# SEA LINK

EN020026

## Comments on Submissions received by Deadline 5

Suffolk County Council

Legend

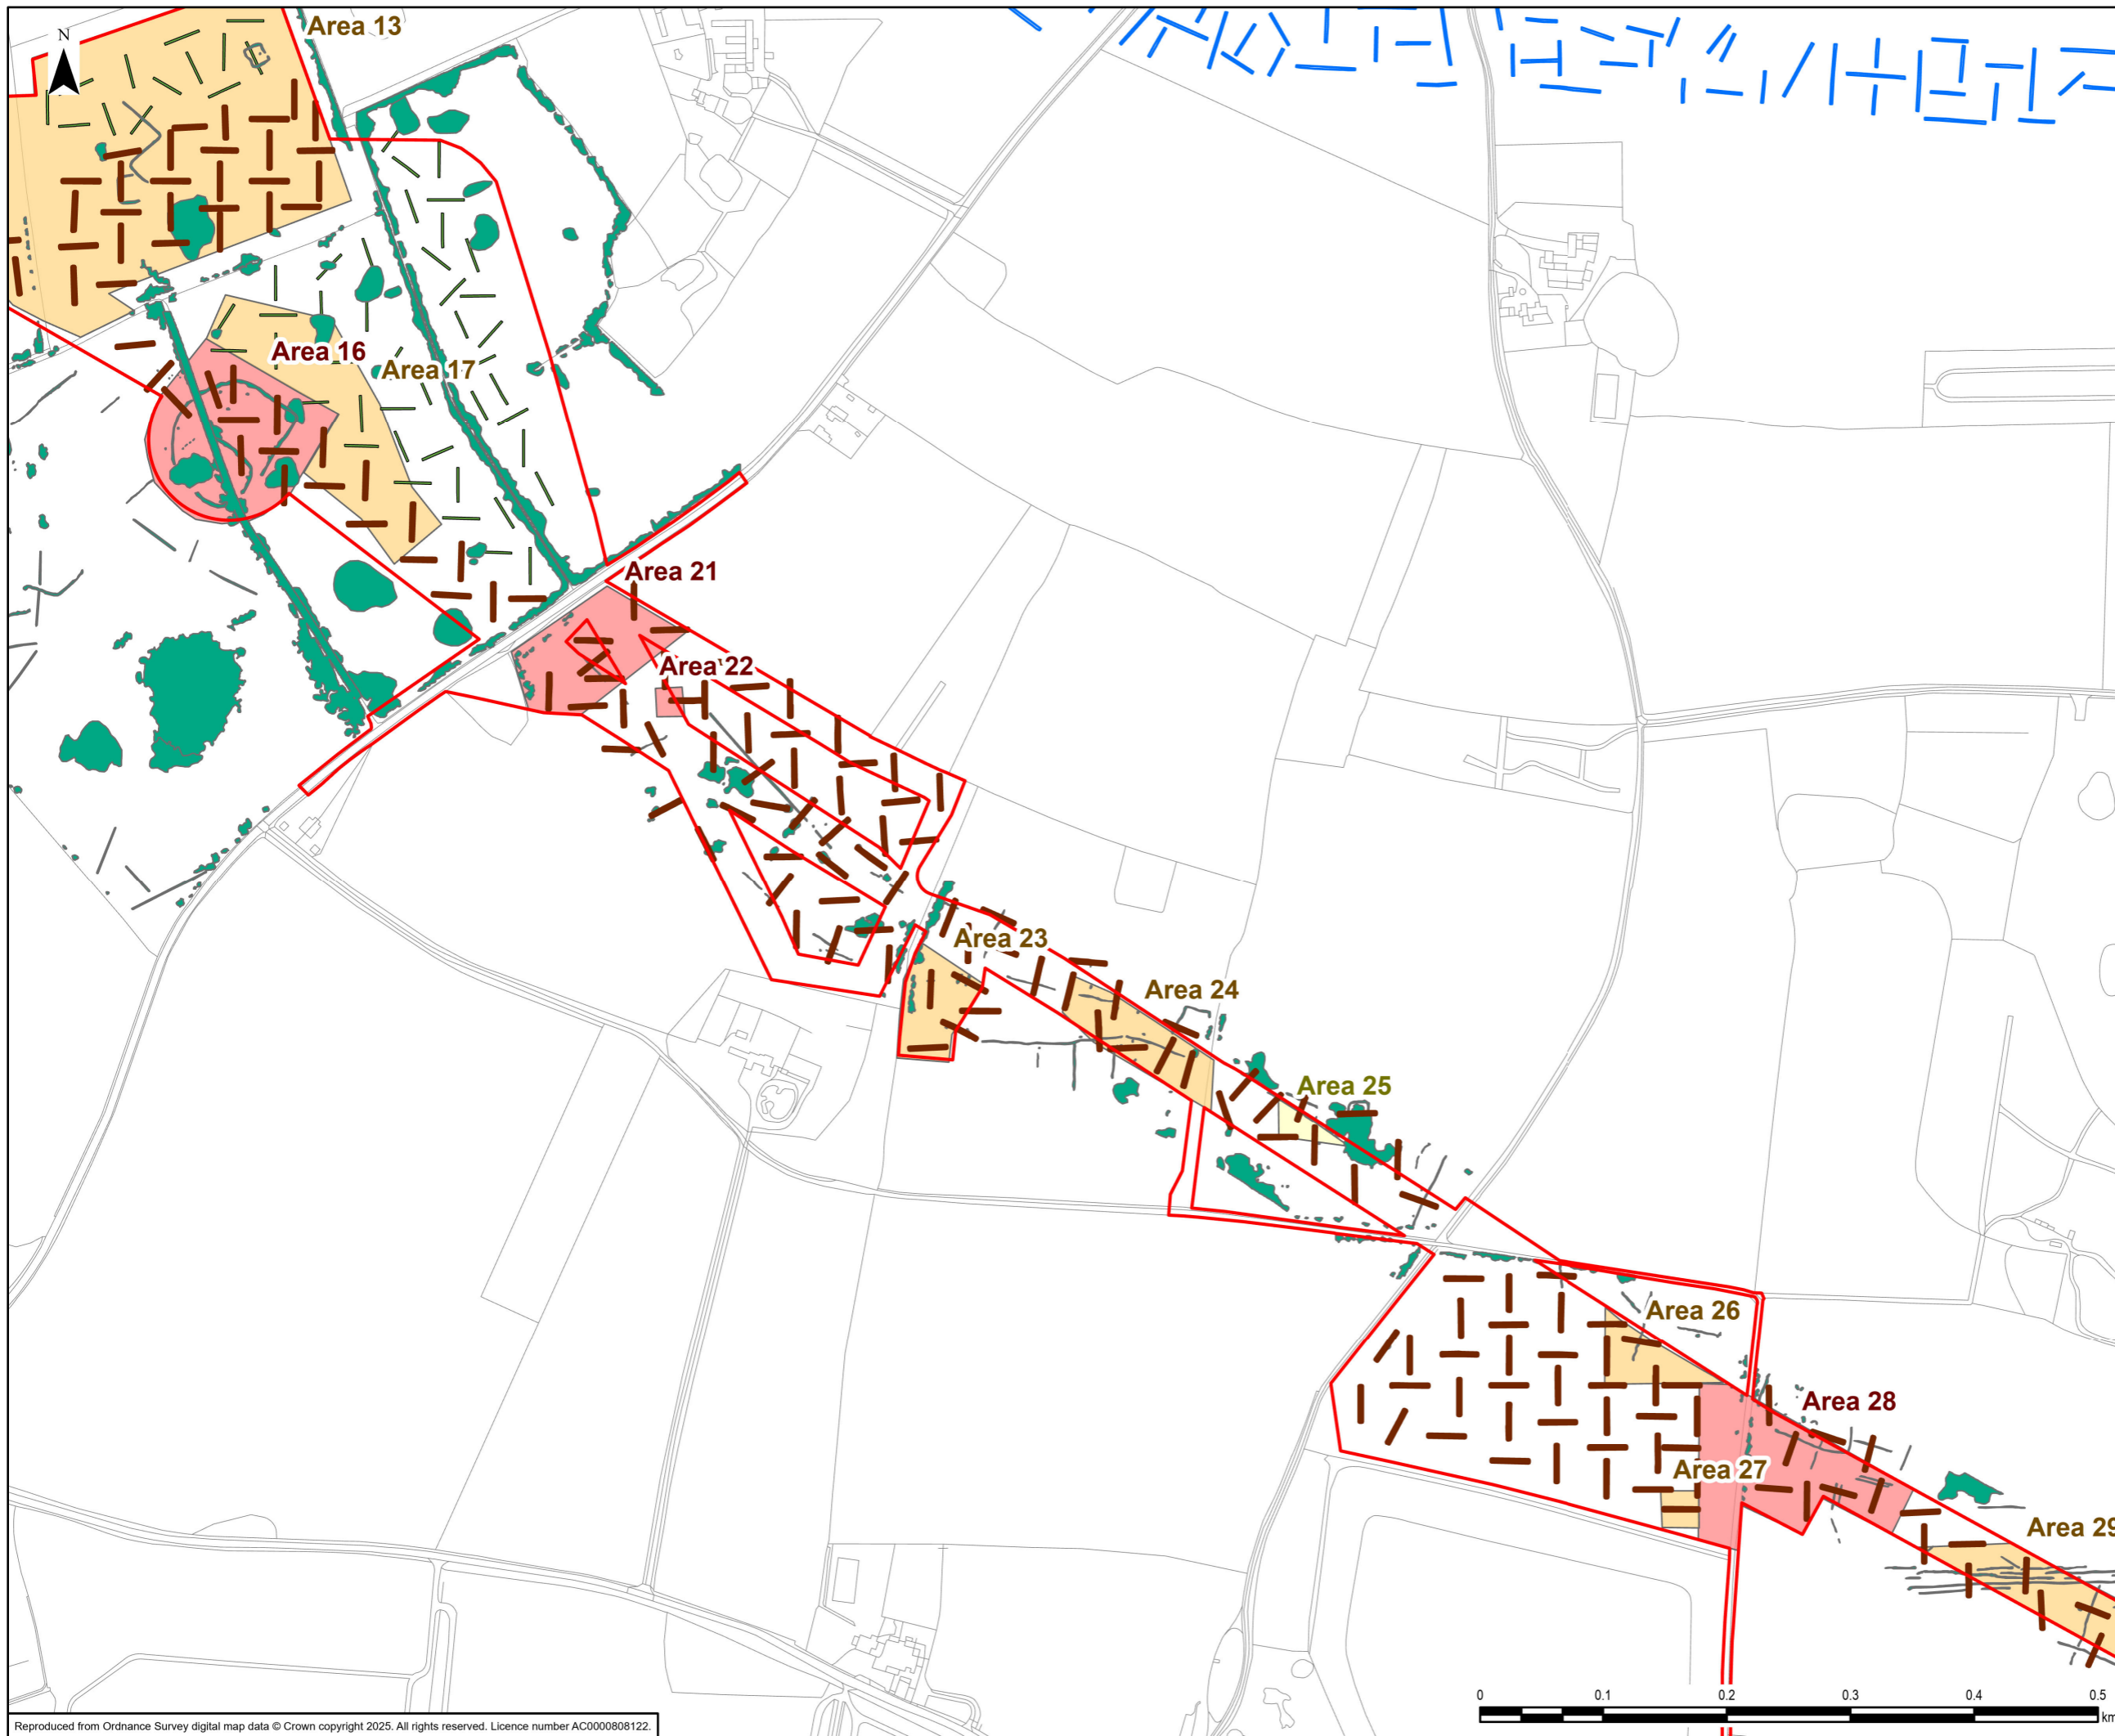
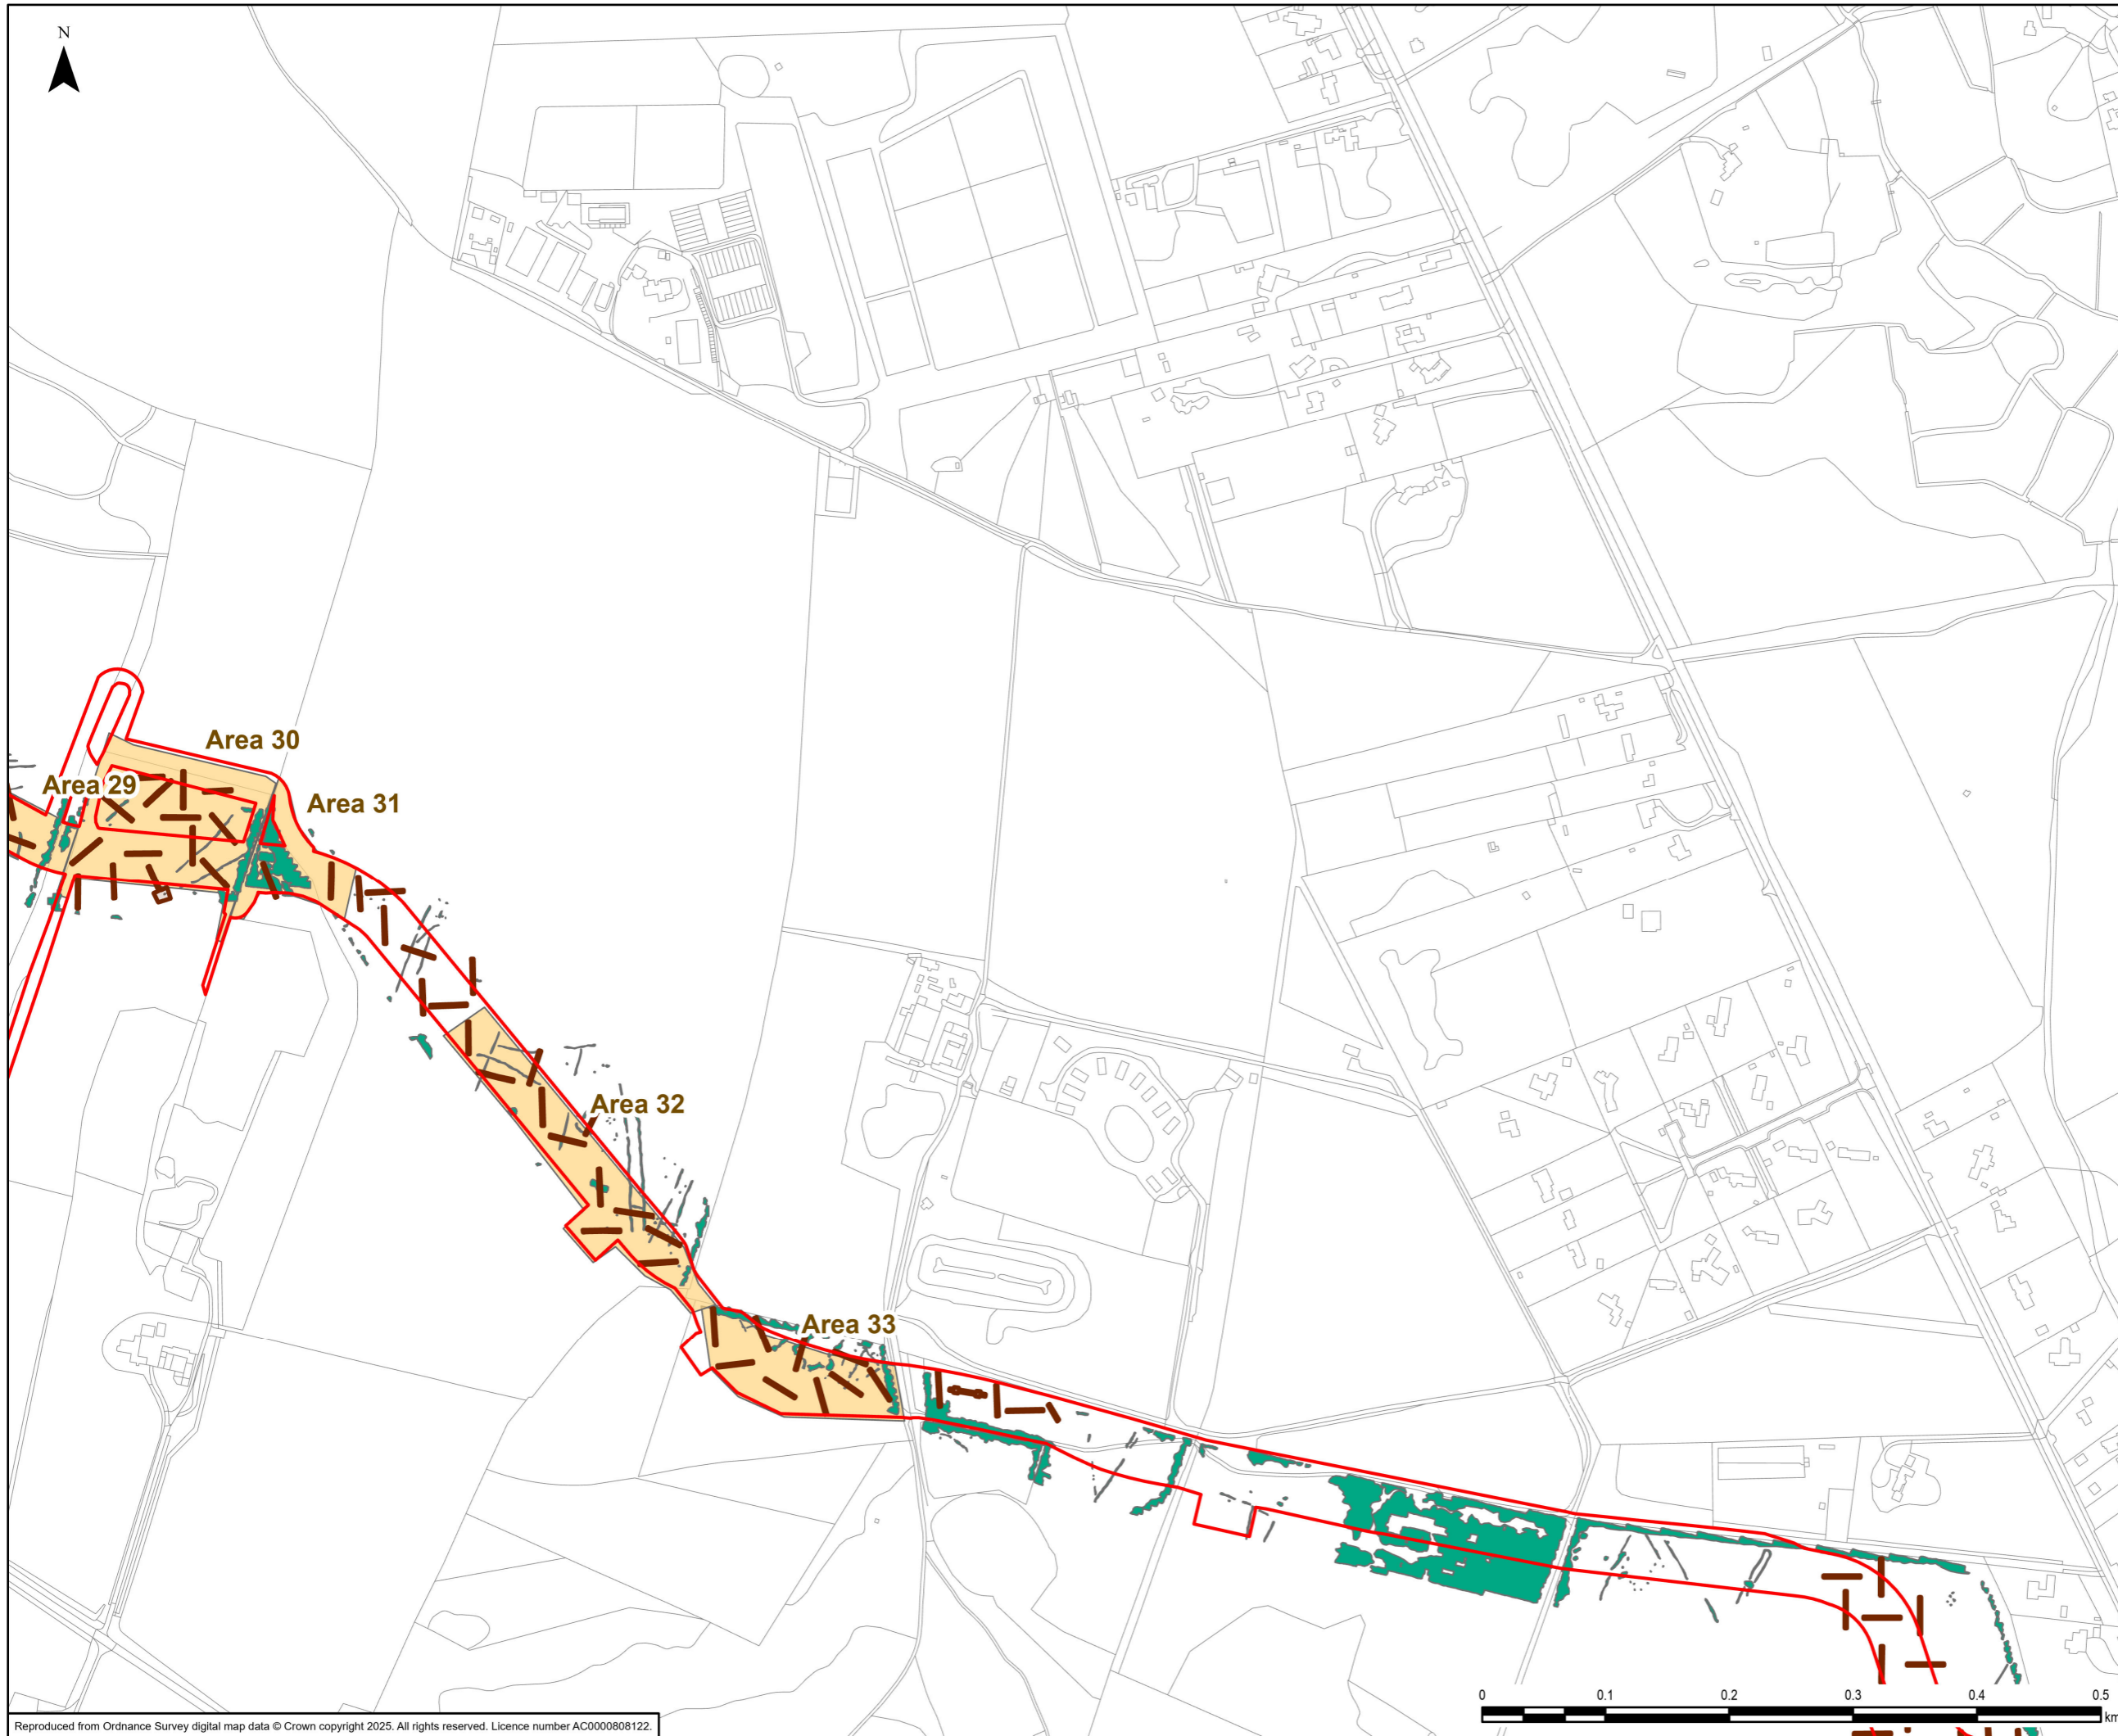
4)		Mitigation areas/scope	<p>1.3.4 SCCAS have provided detailed comments regarding mitigation areas and the scope of the ongoing evaluation and mitigation work which is required for the project to the Applicant’s archaeological consultant. As such, Appendix A is not currently approved as not all mitigation areas are yet agreed and as an up to date and clearer plan showing the evaluation status for different areas of the scheme is needed.</p> <p>However, SCCAS would advise that as the final scope of evaluation and mitigation work will be agreed within the site specific WSIs, that plans showing provisional mitigation areas should be omitted from the OWSI as it is a working document and likely to change.</p> <p>SCCAS would advise that what is required in the OWSI is an up to date plan showing the status of evaluation works for the entire onshore area of scheme in Suffolk and clearly identifying which land parcels have had evaluation works</p>

Ref. No	Topic	Summary of submission	SCC Response
			completed and those where evaluation/assessment is still pending, based upon the latest order limits and works plans.
